Lead Local Flood Authority

Date 24th July 2026

RE: WA/51/26/RES - Land East of Wandleys Lane, Fontwell

5988-005-5552-A05

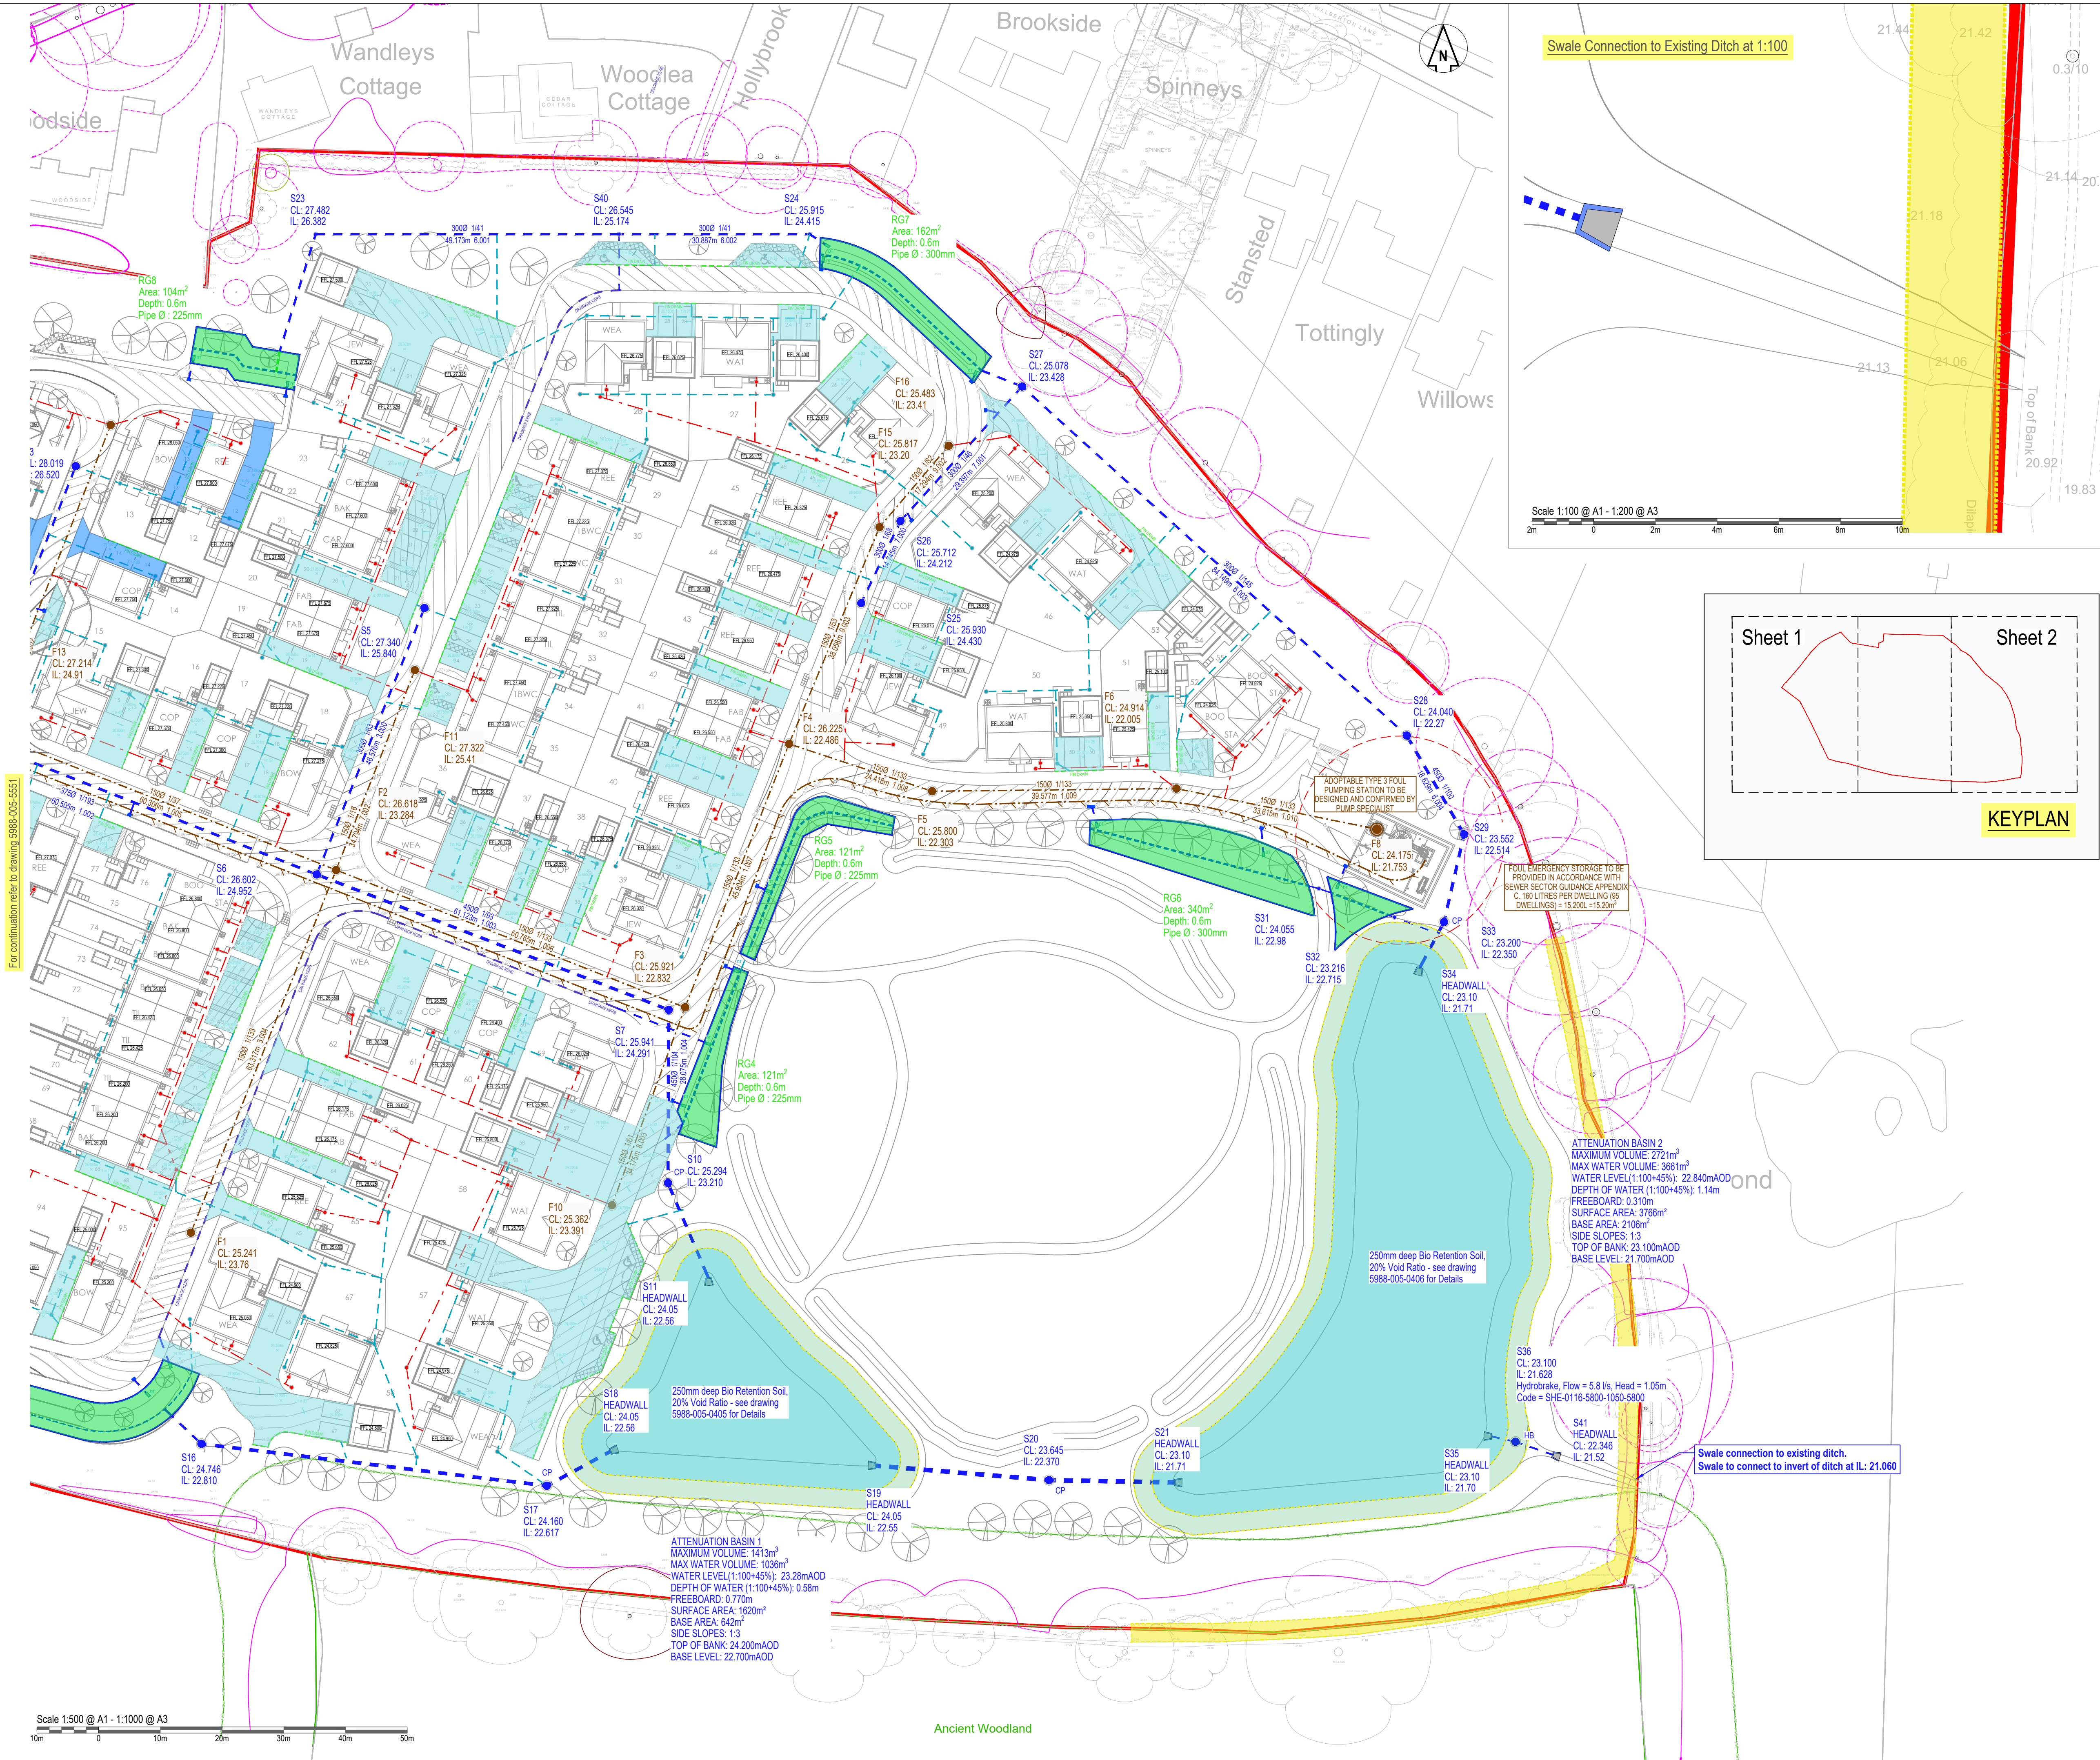
1. There are various discrepancies between the drainage layout and hydraulic modelling calculations:
 - Flow control – in the drainage layout, the flow control rate is 5.8 l/s with design head of 1.05, whereas in the calculations, the flow control rate is 6.2 with design head 1.25. In addition, the hydrobrake reference numbers do not match.
 - Invert level – for basin 1, the IL is 22.7 in the drainage layout, while it is 22.5 in the calculations.
 - Maximum basin volume – for basin 2, the max volume is 2522 m³ in drainage layout, in the calculations it is 2780 m³
2. For the climate change allowances, Upper and Bedford Ouse catchment is referenced – climate change allowances shall be site specific.

Swale Connection to Existing Ditch at 1:100

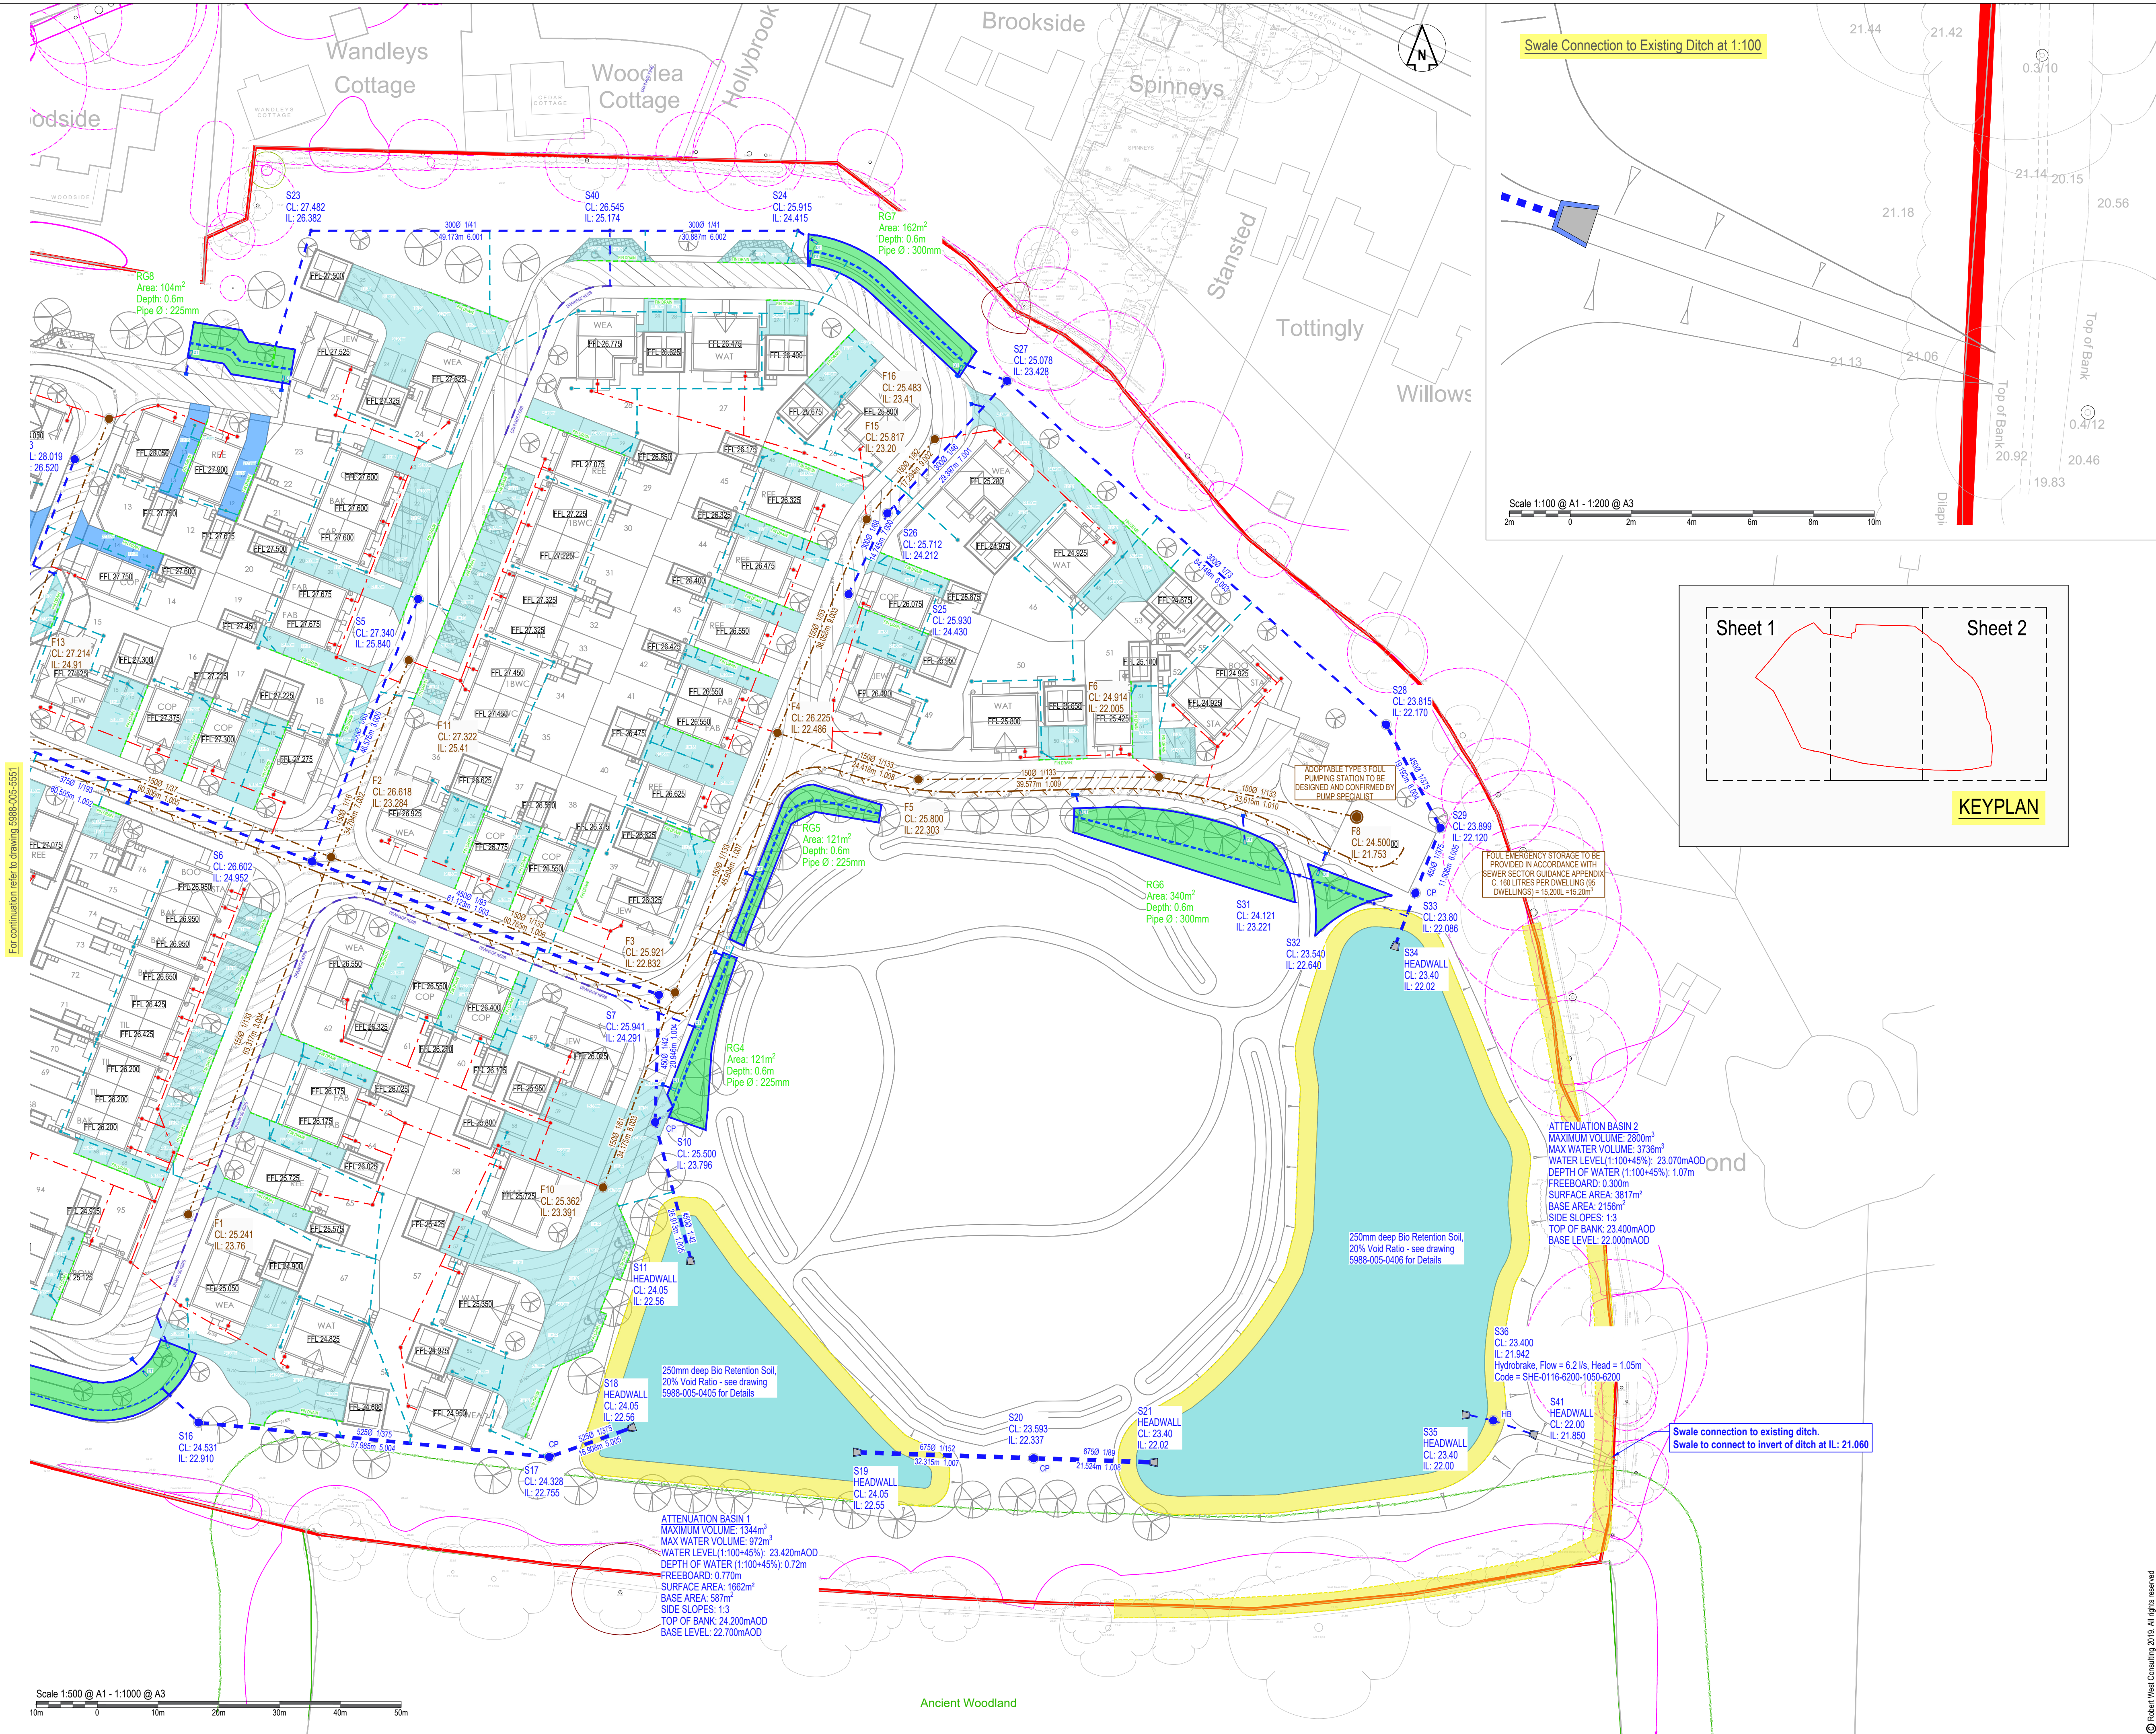
3. There is no mention of rainwater harvesting (1st method in drainage hierarchy). For avoidance of doubt, cost is not an adequate reason to not include rainwater harvesting.
4. Evidence of the watercourse connectivity to the wider network is required.
5. A surcharged outfall may be required – we would recommend completing a topographical survey of the watercourse, to support any further information.
6. For interception, we would suggest filling in the example table below, and ensuring it corresponds with the contributing area plan:
